DECISION DELEGATED TO HEAD OF PLANNING

Application No: H16-0748-23 **Applicant:** Newton Penstar Ltd.

Proposal: Change of use of two-storey garage/annex to two studio flats - Part Retrospective

Location: Willow Villa 10 Green Lane Spalding

PROPOSED GF PLAN
SCALE 1:100

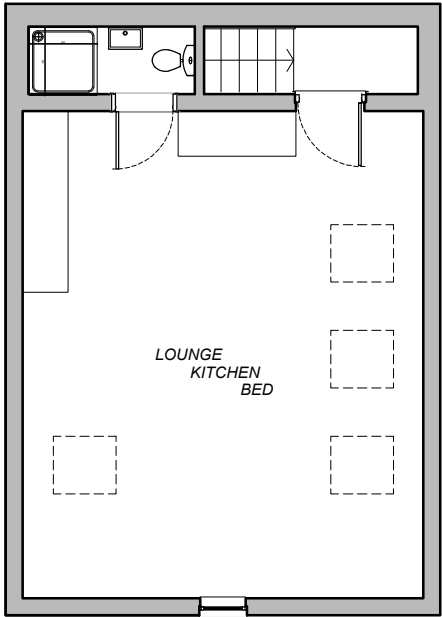
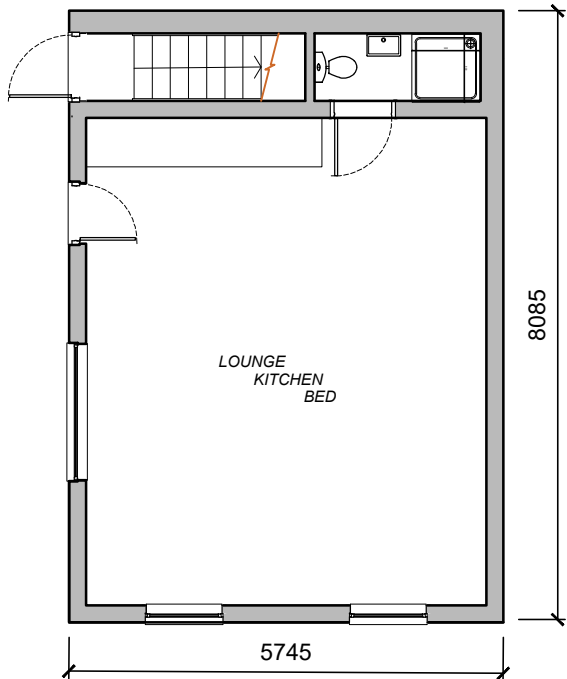
Also of note is that the policy requires "the Nationally Described Space Standards (or any successor) will be applied to ensure that the occupiers have adequate floor space. The national space standards state that the minimum requirement for internal floor space is 37sqm (if a shower room is provided rather than a bathroom). Both flats measure just under 36sqm (34sqm for the main space and just under 2sqm for the shower room with toilet). As both flats fall below the required space standards point 'f' of the technical requirements is considered relevant, it states:

"any area with a headroom of less than 1.5m is not counted within the Gross Internal Area unless used solely for storage (if the area under the stairs is to be used for storage, assume a general floor area of 1m² within the Gross Internal Area)".

The upper floor is located under the roof structure and partly above the eaves. The applicant has not provided a cross section (of hatching) to understand how much of the first floor can be counted as floor space under the standards. Notwithstanding this the overall floor space is below requirements it is considered that the space provided is likely to be substandard.

It is therefore considered that the proposed studio flats would not provide an adequate level of amenity for future residents. The flats fall below the 'Technical housing standards - nationally described space standard' (March, 2016), furthermore no external amenity area is provided for future residents. The proposal is therefore considered to be contrary to policies 21, 2 and 3 of the SELLP 2019.

H16-0748-23

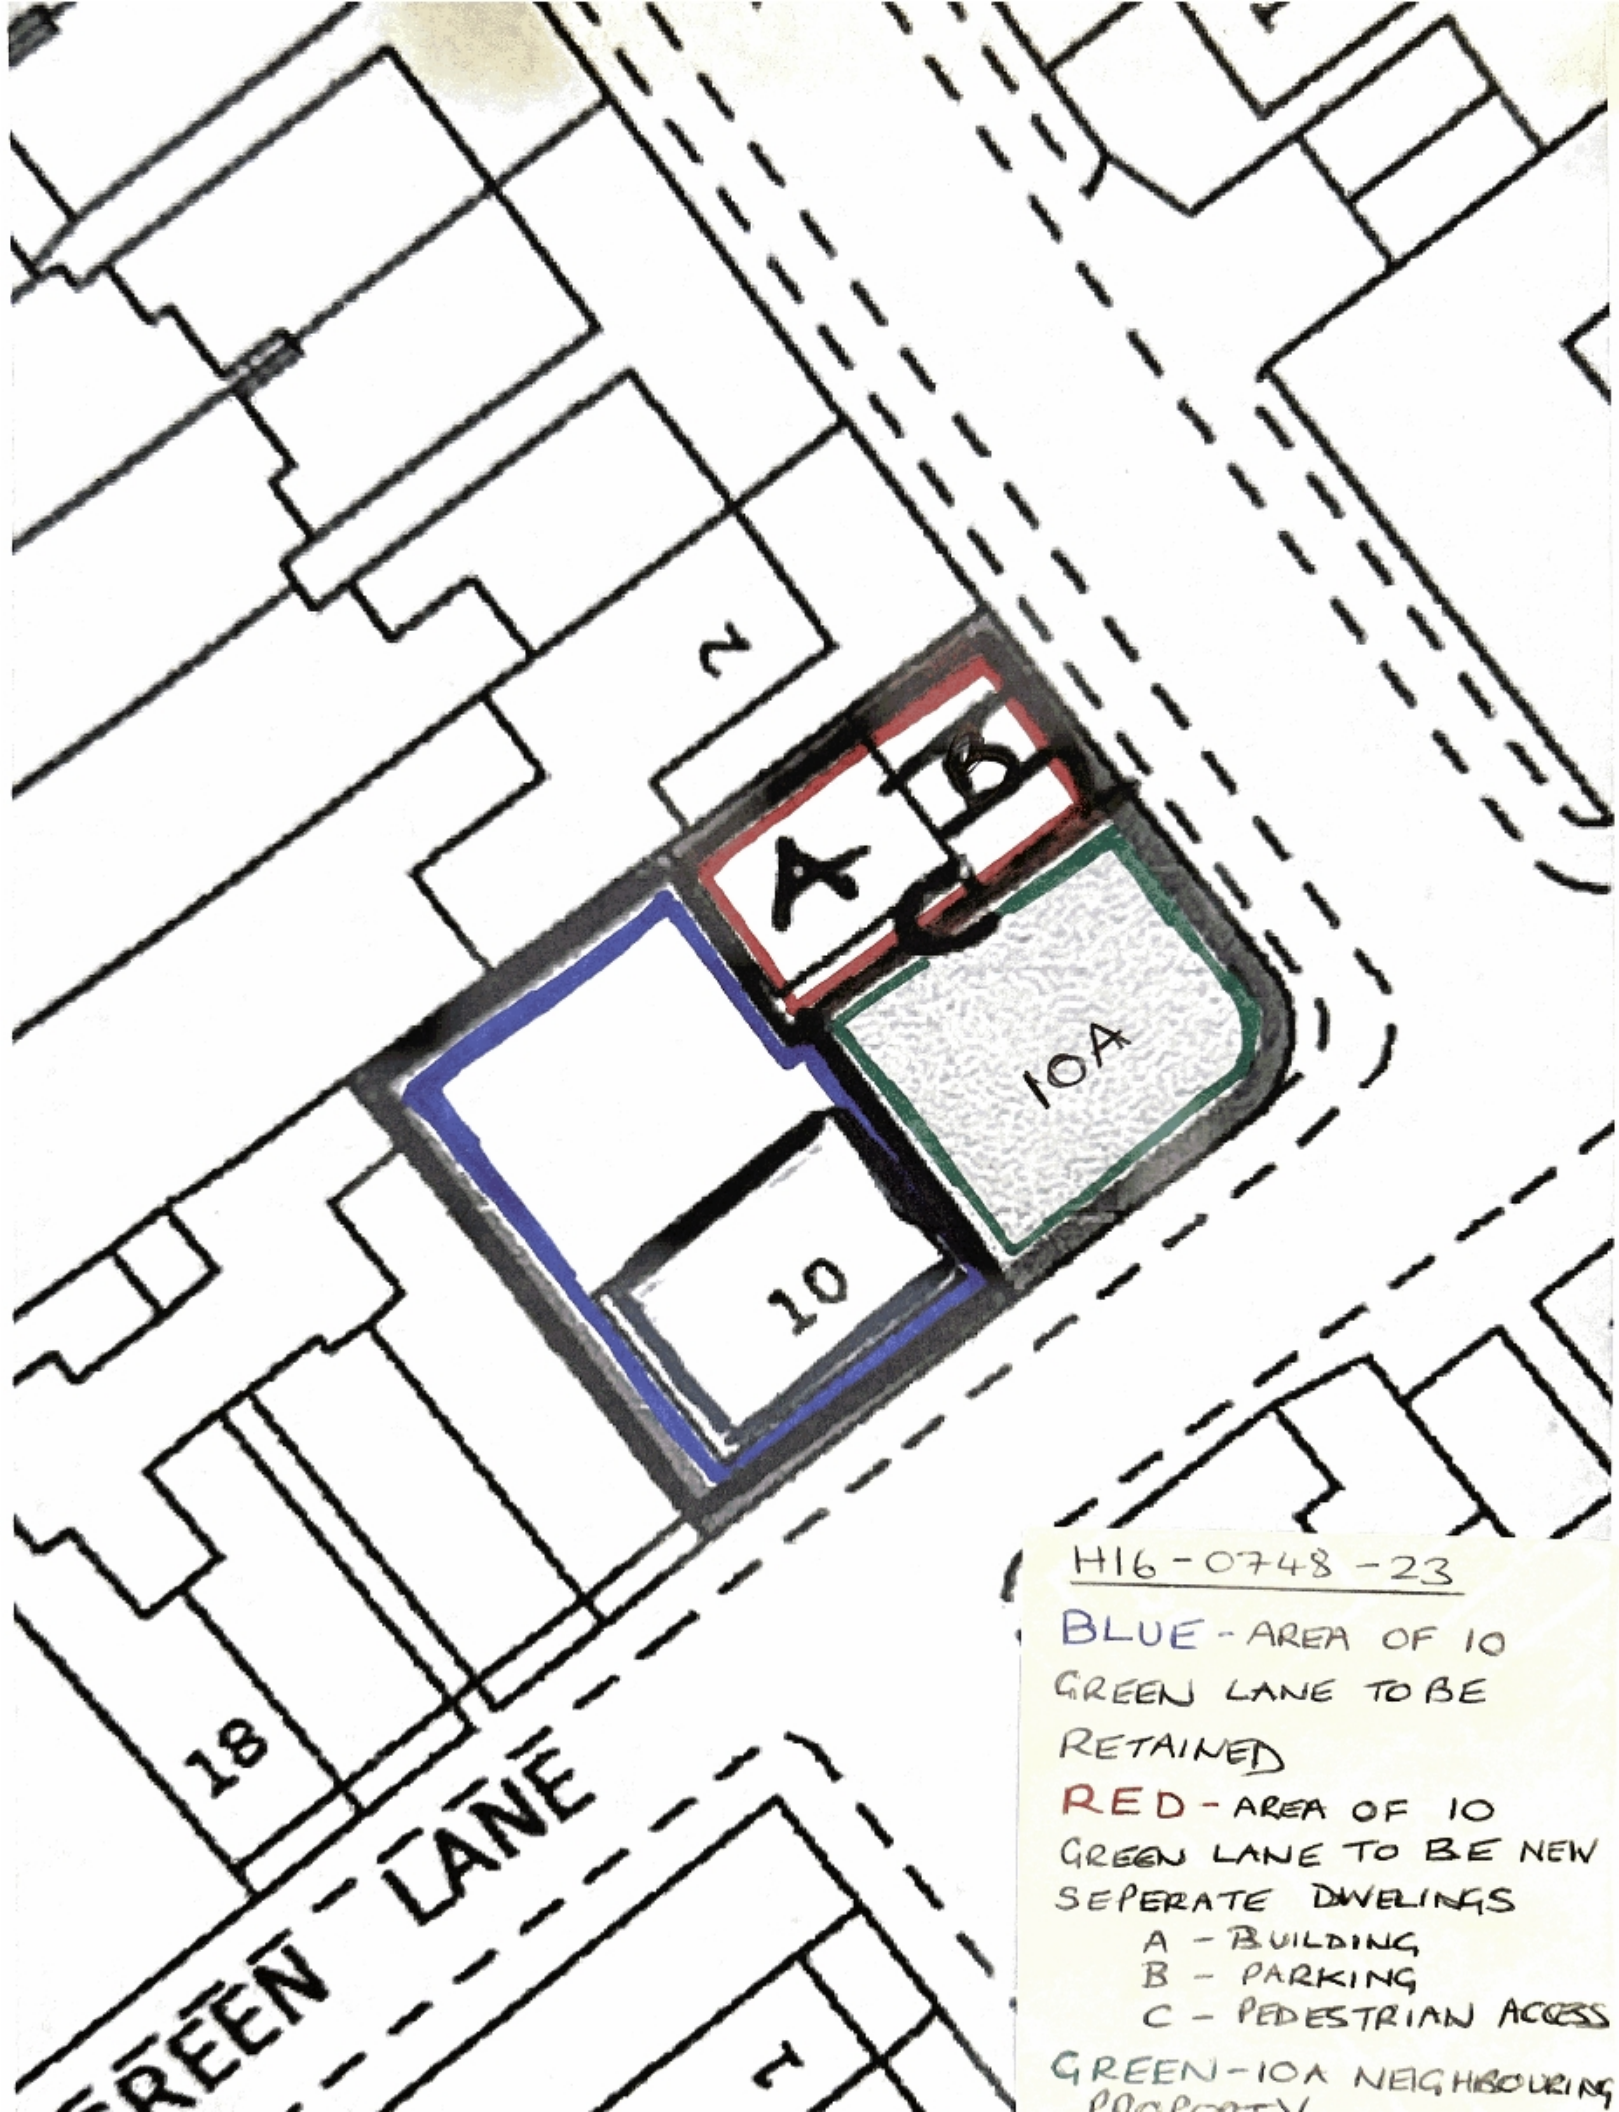
Point 8 of policy 21 requires that 'adequate provision is made for the communal gardens and amenity areas' is provided. This is supported by policy 3 which requires 'residential amenity' to be considered in relation to the design of new development. The site plan shows that no external amenity area would be provided for the flats. The lack of external space provided compounds the issue of amenity for future residents. This lack of space would also raise questions as to where refuse bins will be kept.

An important consideration in terms of parking is not only the parking provided but the parking lost by numbers 10 and 10a Green Lane. Planning application H16-1097-07 allowed for a 3 bedroom dwelling on the corner (between number 10 Green Lane and Knipe Avenue), the approved plans allowed for the provision of two of these three spaces to be used by 10a, the other remaining for the purposes of number 10 Green Lane. This was reaffirmed under planning application H16-0133-09 (extension of garage, allowed at appeal) where two of the three spaces were within the blue line boundary associated with number 10 Green Lane and not within the red line of the application site. From site visit it is clear that one of the spaces has been absorbed behind a fence into the garden area of number 10a Green Lane, leaving two spaces to the front of the garage one of which should be for the use of number 10a. This proposal seeks as confirmed within the application form two

number spaces for the flat and 1 number space for No. 10 Green Lane, showing 3 spaces to the front of the garage. Three spaces would not fit into this area however, the garage has a width of circa 5.7m and even with the addition of the narrow walkway along the southern elevation of the garage not enough space to park three vehicles would exist, the space available is therefore for two number vehicles only. It total there are 3 number spaces to serve two family size dwellings and potentially two number apartments (Numbers 10 and 10a Green Lane and this proposal). This arrangement is unsatisfactory and contrary to the parking requirements set out under appendix 6 of the plan.

Another issue relates to the space afforded for bins/waste storage; it is unlikely that bins could be stored to the front of the flats as it would encroach on parking space. Whilst the red line boundary runs tight to the rear of the building it is therefore not clear where these would be stored.

Notwithstanding that there are no on street parking restrictions, it is considered that the proposal would represent an under provision of off-street parking provision. If the flats are allocated two spaces, then only 1 parking space is available between two family sided dwellings, This is unacceptable and contrary to appendix 6 of the South East Lincolnshire Local Plan.
